# CITY OF ALBUQUERQUE

April 7, 2011

**Re: Osuna Elementary School Grading Plan, Paving Plan, and SO-19 Permit  
Engineer's Stamp date 3-13-11 (F20/D010A)**

DEVELOPED
CONDITIONS
PLAN

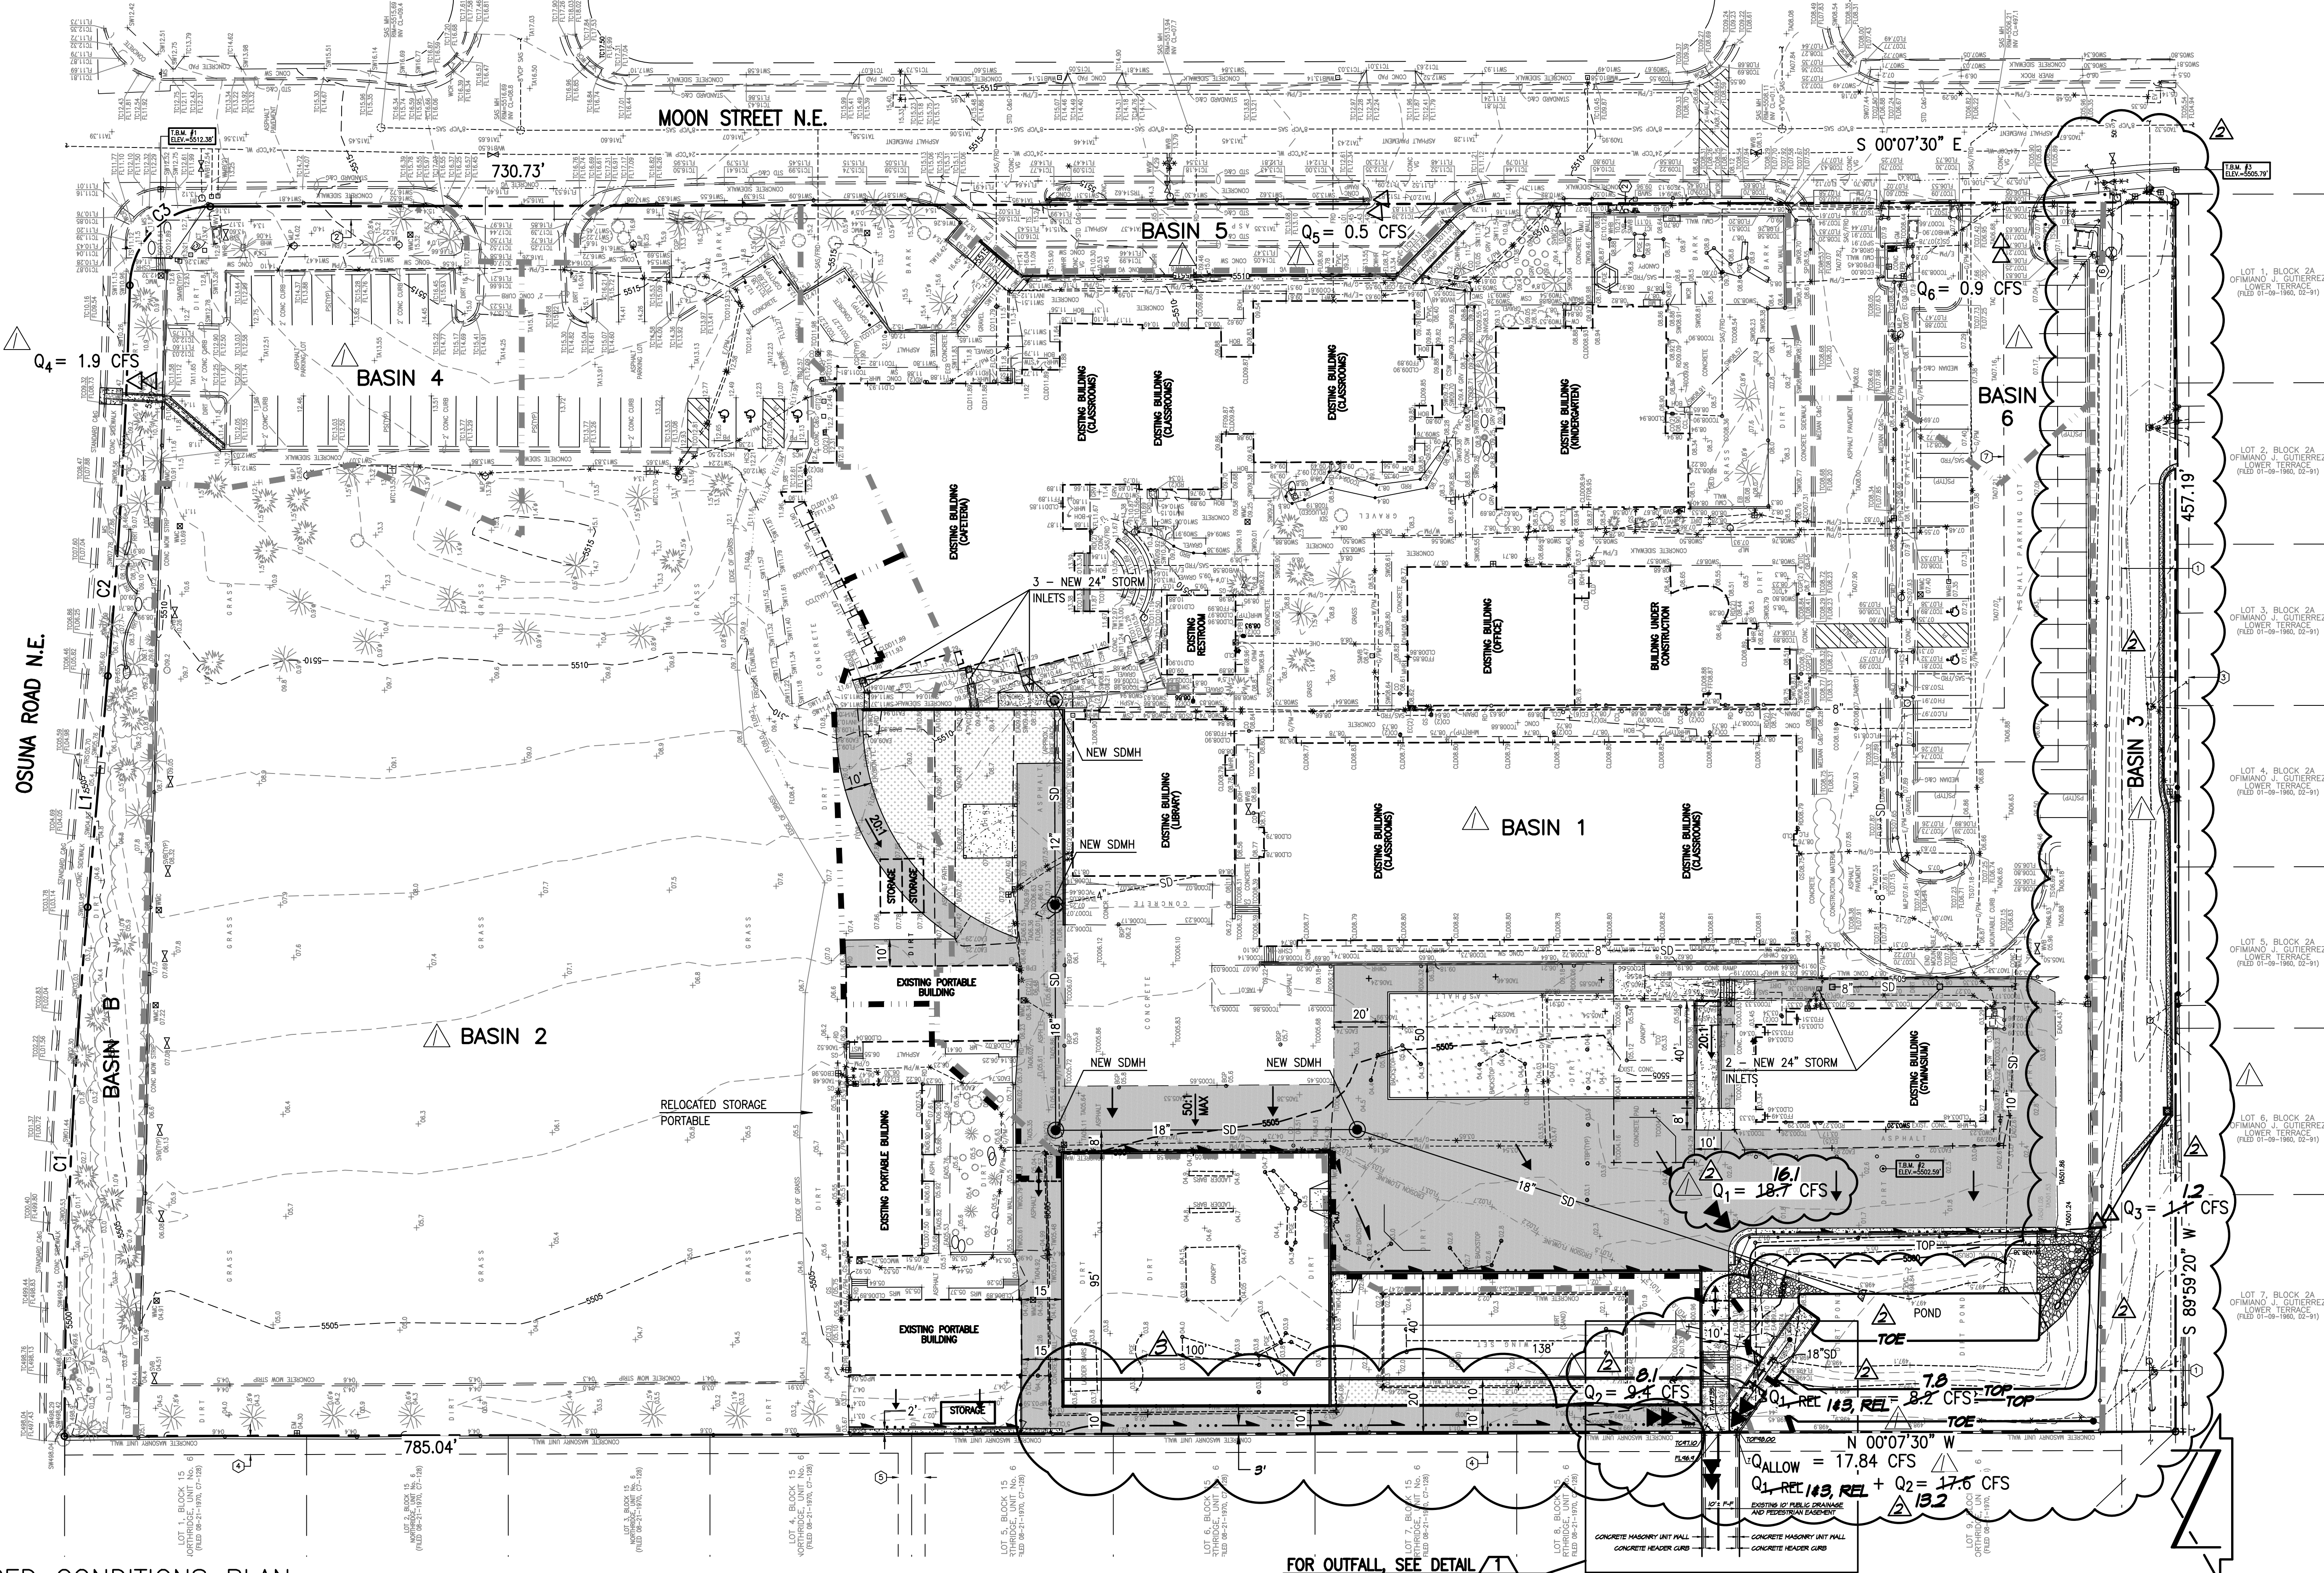
- It appears that the runoff from Basin 2 runs down the western property line along the CMU wall. It would be preferred to have the runoff drain away from the wall near the centerline of the asphalt pavement.
- It appears that the 4" storm drain (INV 06.00) tying into the new SDMH #3 (RIM 06.50) does not have enough cover. Please provide a detail specifying how this is to be done.
- There has been a recent modification to the approved standard sidewalk culvert detail (COA STD DWG #2236), please see attached detail. If another design is desired, please contact Curtis Cherne in Hydrology at 924-3695 for further approval.
